Application no: H16-0146-15

Description: Details of external materials and position of meter boxes, gas flues and vent pipes (conditions 4, 5 and 6 of H16-0828-14)

Amendment: Alteration to brick type
(Dwg no. 13/338/PA/011A)

ACKNOWLEDGEMENT OF AMENDMENT

Drawing No. **13/338/PA/011A**

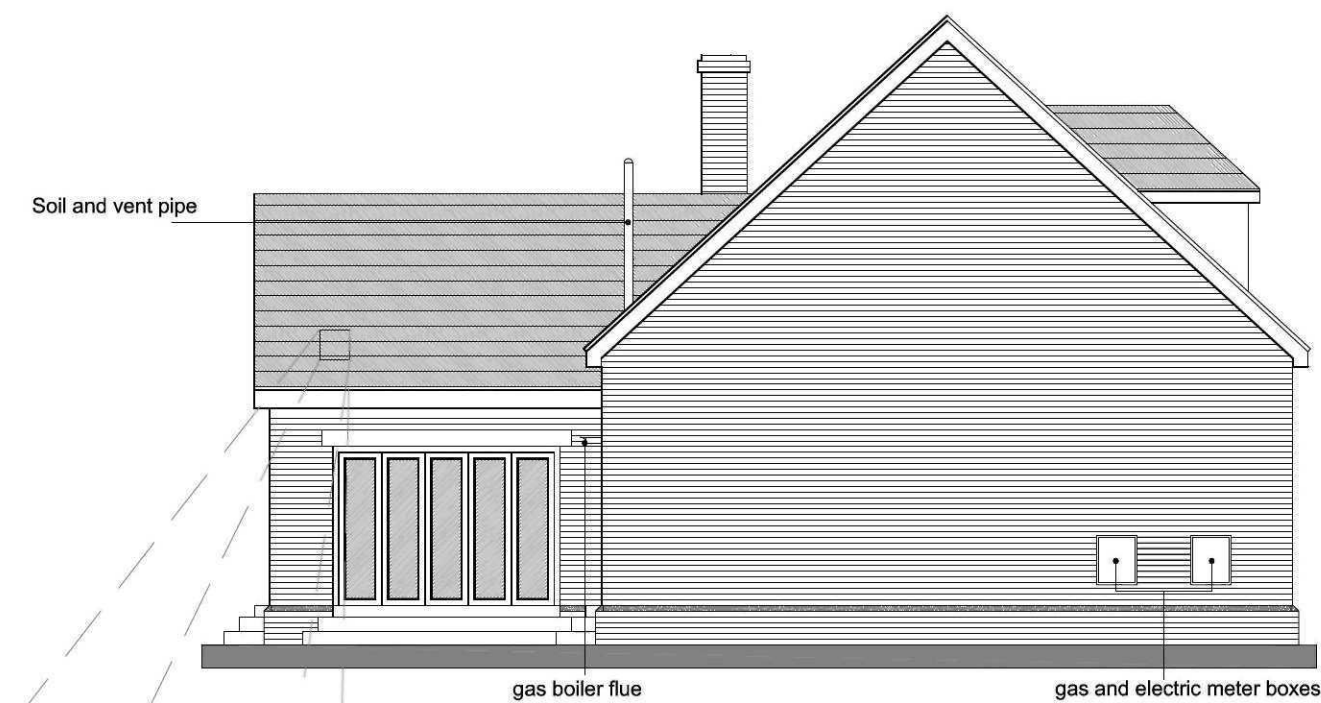
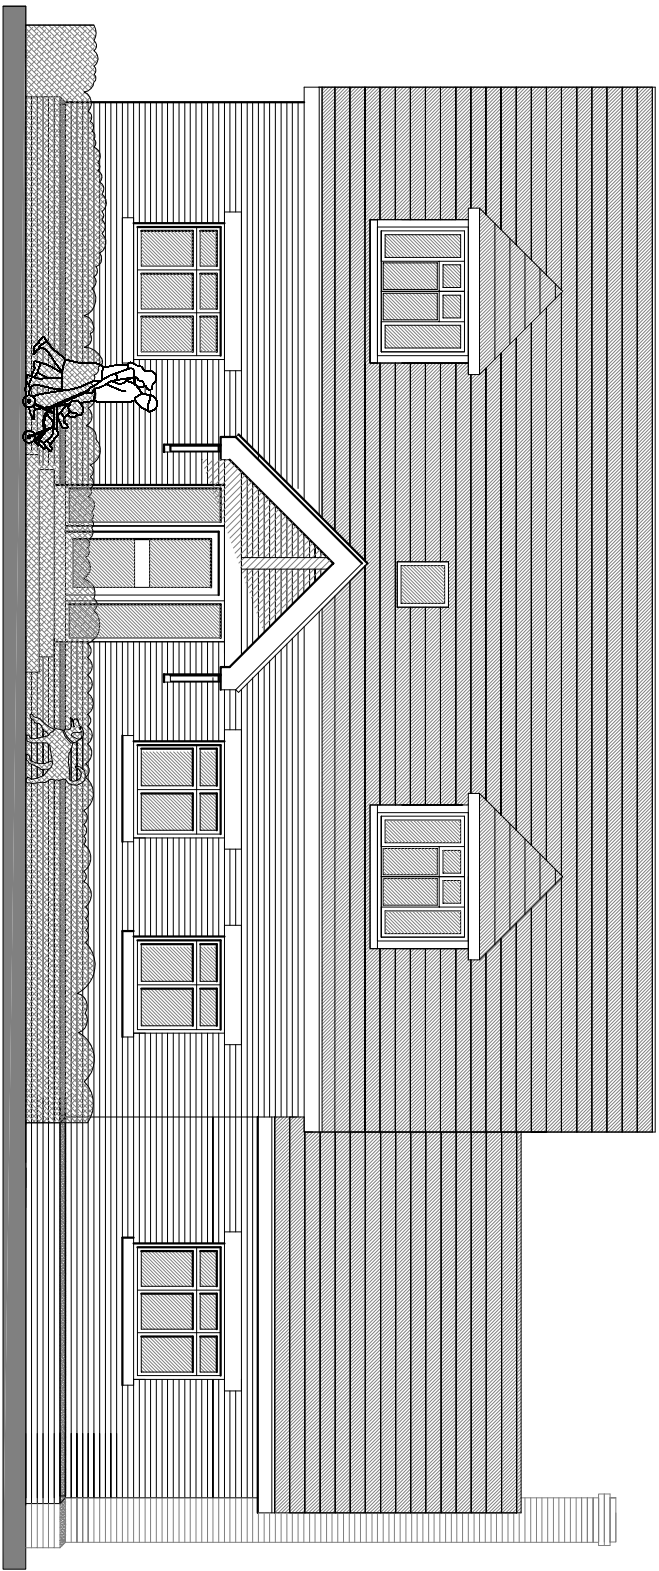
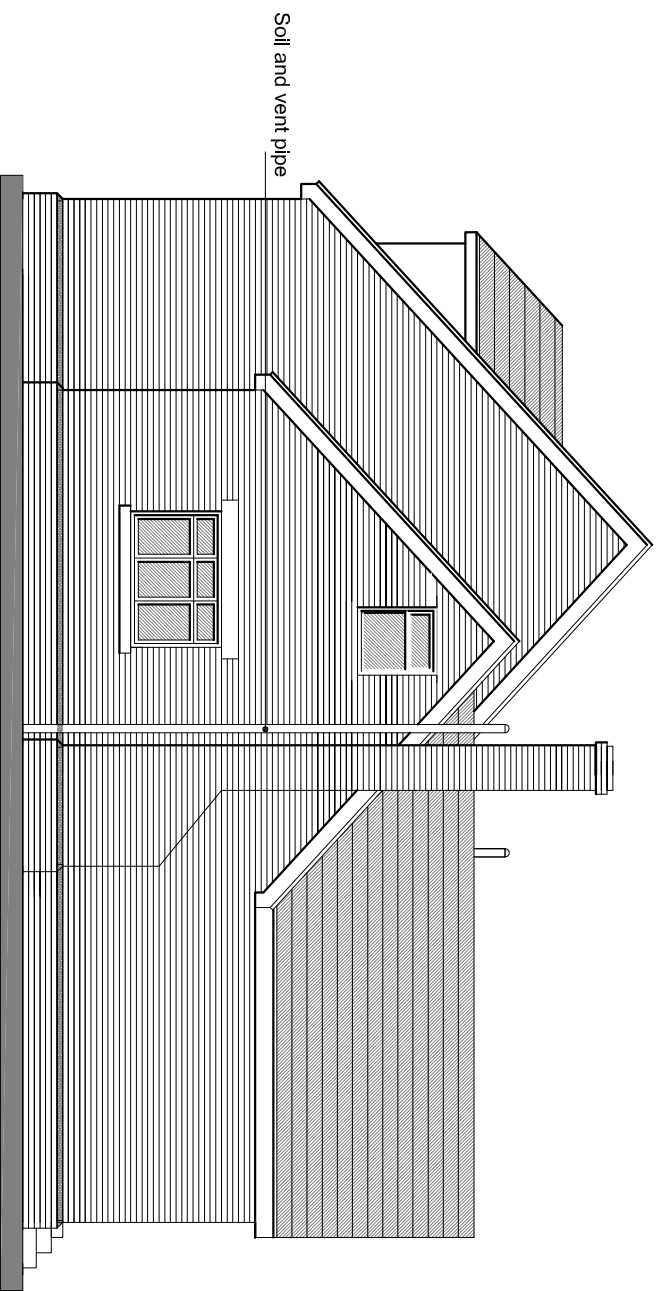
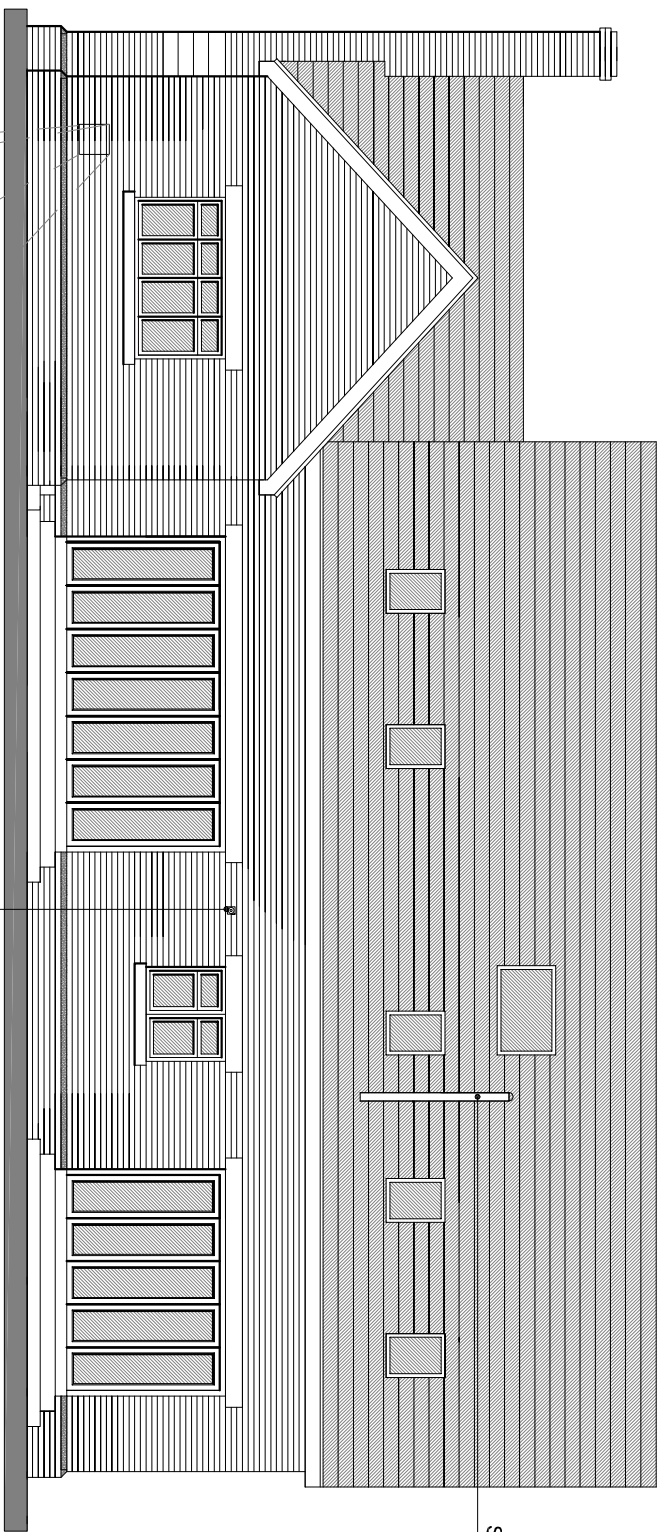
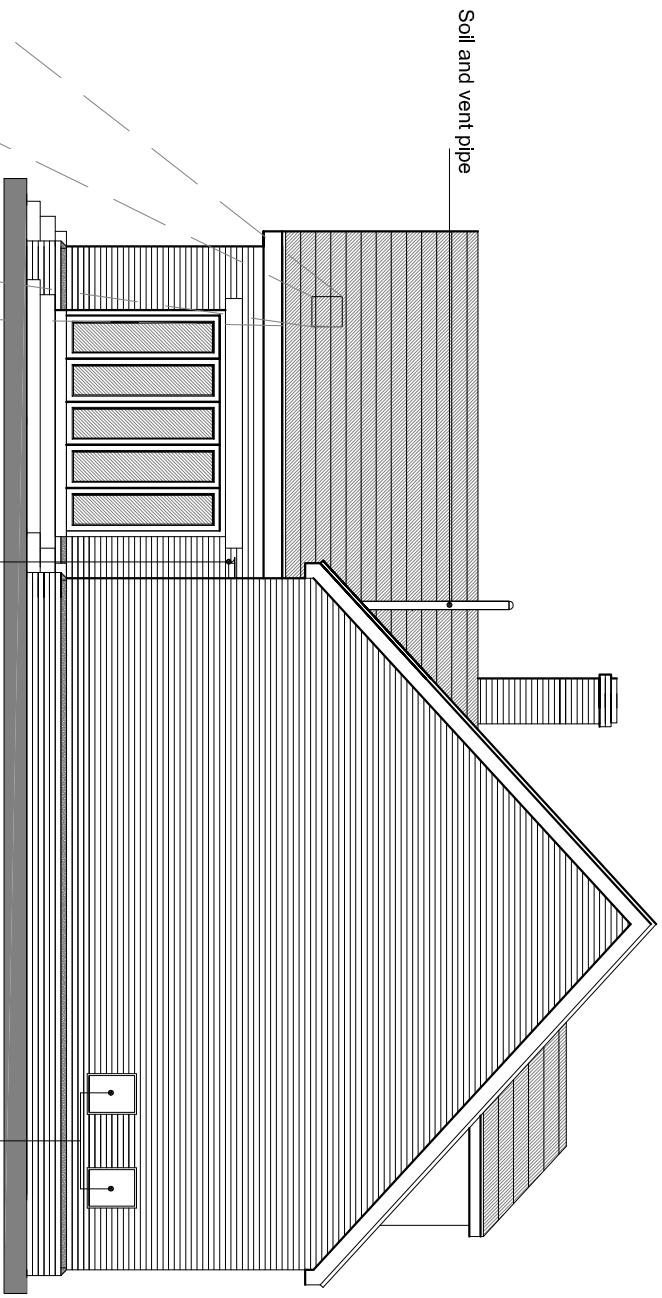
Please find attached amended drawing and the appropriate form for the alteration of brick type for the above application.
